Consultation Response from KC, Policy		
2021/90357 East Bierley Playing Fields, Hunsworth Lane, East Bierley, BD4 6PU		
Works to existing sports facilities including erection of a clubhouse, additional changing facilities building, boundary treatments, storage facilities and floodlighting, works to existing pitches, and creation of new hybrid and five-a-side pitches and car park		
Date Responded:21/07/2021	Responding Officer: Amanda Potter & Andrea Lane	Responding Ref:

Proposal:

Client	Title			
East Bierley Community Sports Association	Proposed Changing Rooms Floor Plans			
Project	Job No.	Dwg No.		
Estates Strategy	EBSCA02	09A		
	Scale	Date	Drawn	Checked
	A3@1:100	Dec 20	AW	SA

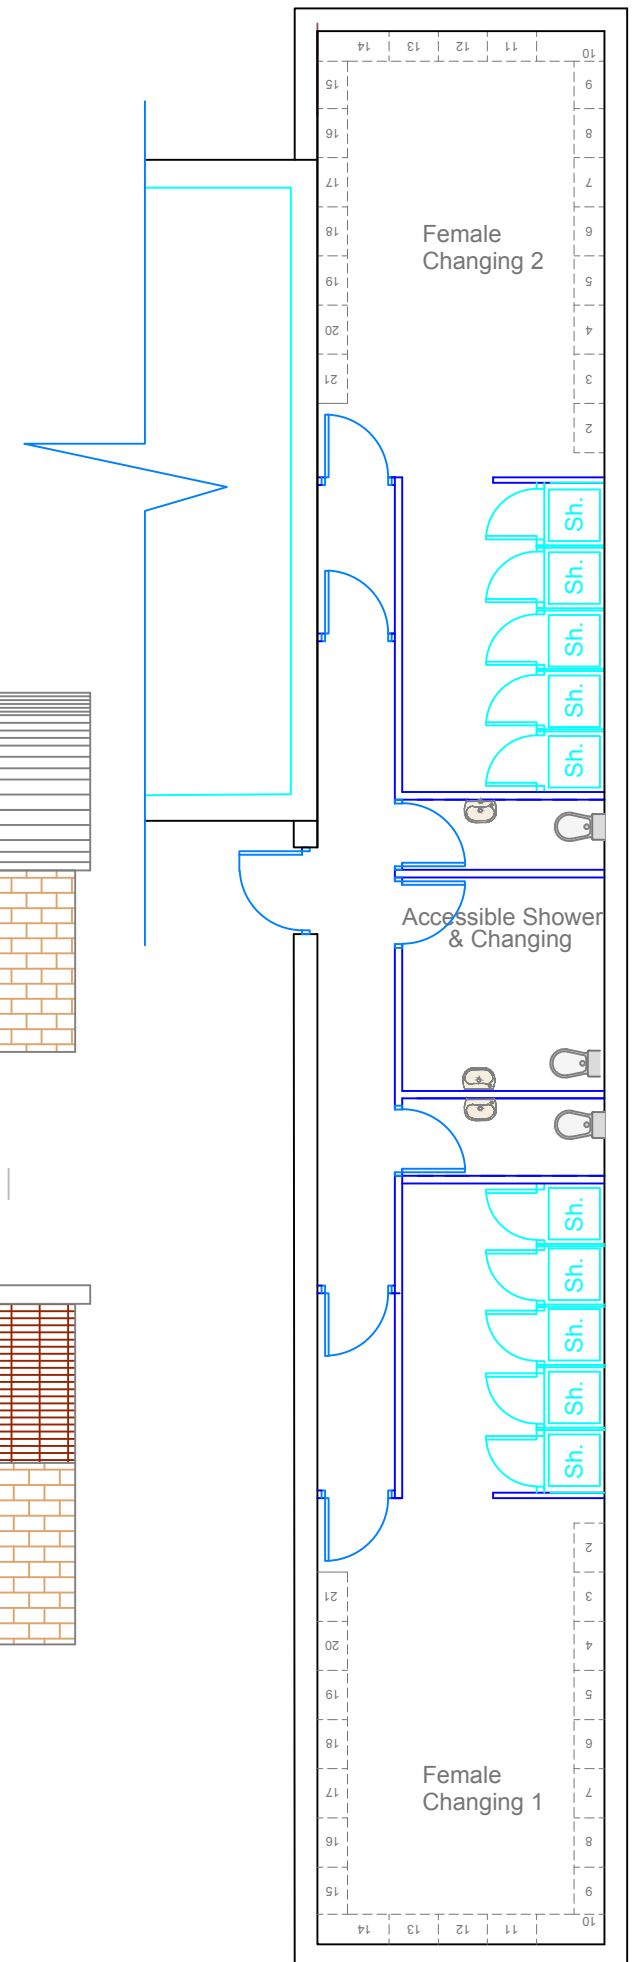
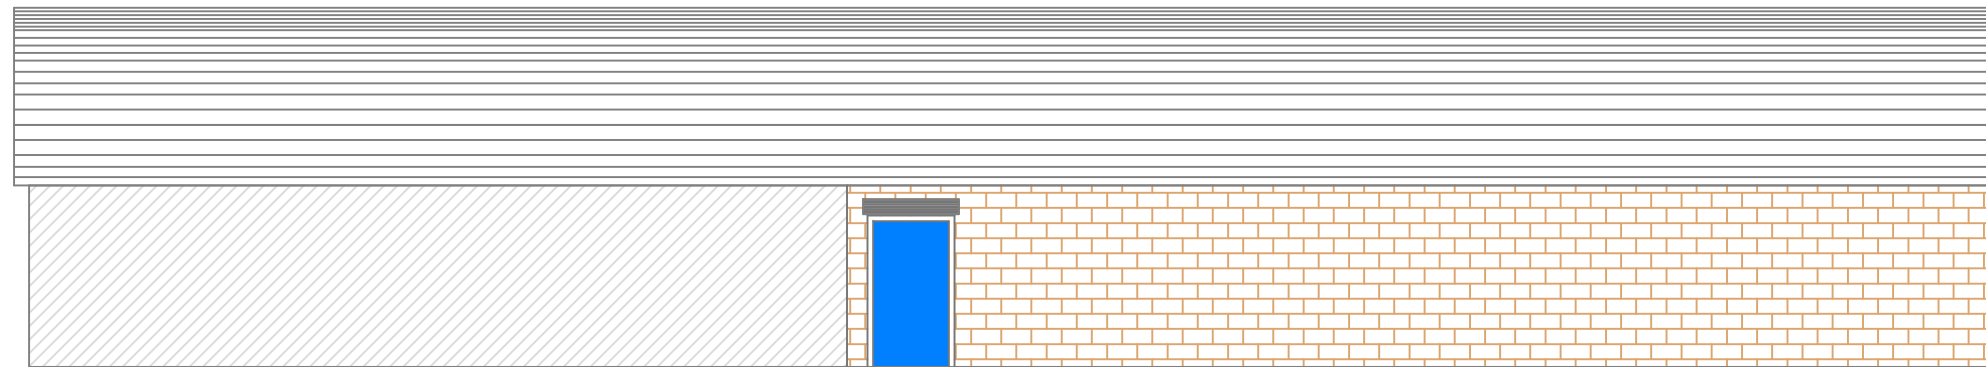
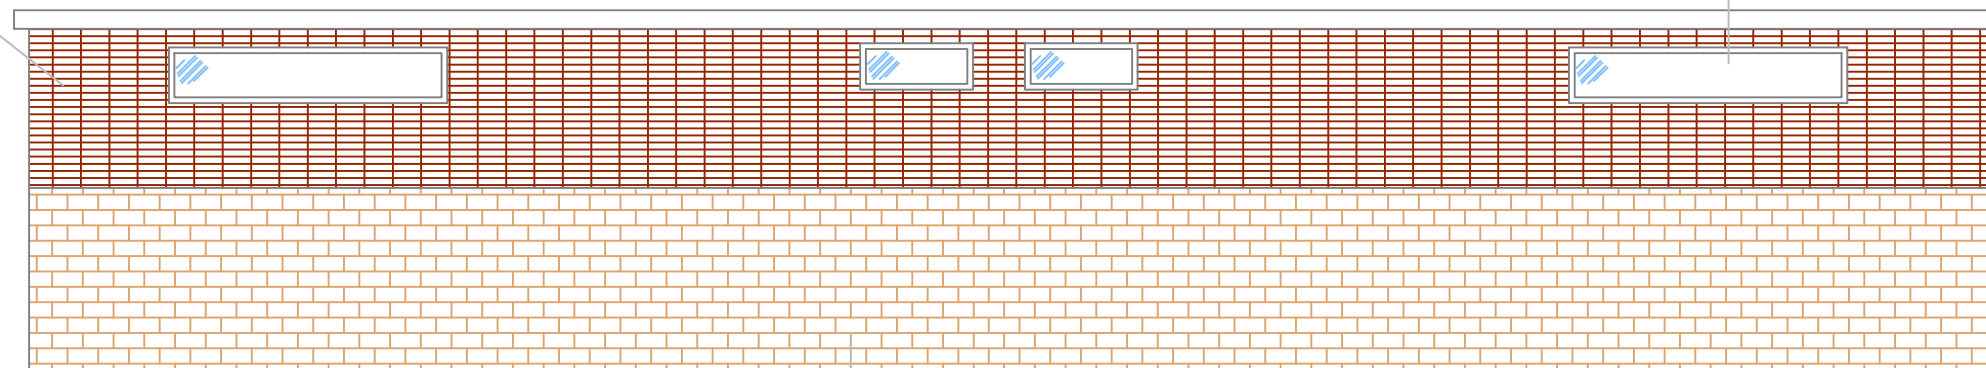
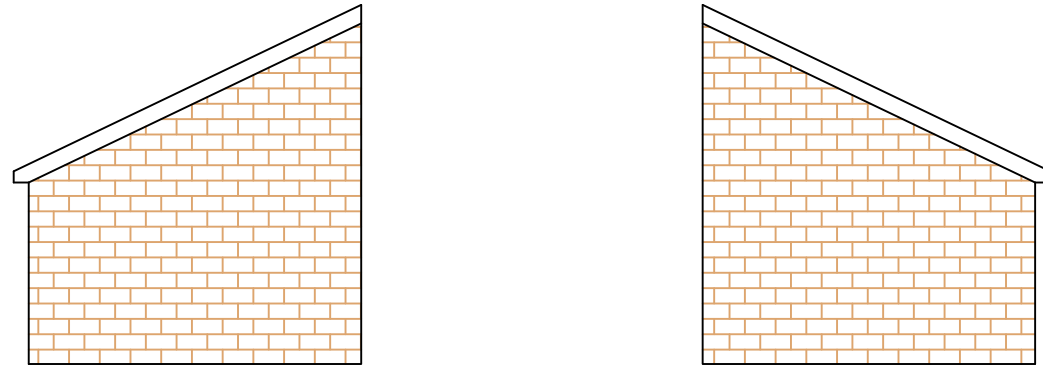
The application also proposes the change of use of an area of pasture at the rear of the existing changing rooms to accommodate a new changing room building, additional to the existing changing rooms building which is proposed to be retained. Some additional car parking is also proposed in this area. This new building should be considered against paragraph 149 criterion b) as an appropriate facility for outdoor sport as changing rooms would reasonably be required on such a site. However, there is no information as to why it is necessary to have 2 changing room buildings on site. A new building where no building currently exists would not preserve the openness of the green belt and the expansion of the site beyond its current limits would lead to encroachment into the countryside contrary to the purposes of including land within it. To compensate for the loss of the area of pasture the plans show a new area of pasture to the south of the site. However, the compensatory area of pasture would be created where land is already free from development while the pasture to be lost would be to accommodate a building and car parking. The one does not therefore compensate for the other.

The new multi-function club house building is not an appropriate facility for outdoor sport and therefore constitutes inappropriate development in the green belt. There would be a requirement for additional car parking spaces as a reasonable consequence of the redevelopment of the pitches. However, car parking to serve the clubhouse is inappropriate in the green belt as it would not preserve openness and would conflict with the purposes of including land in the green belt.
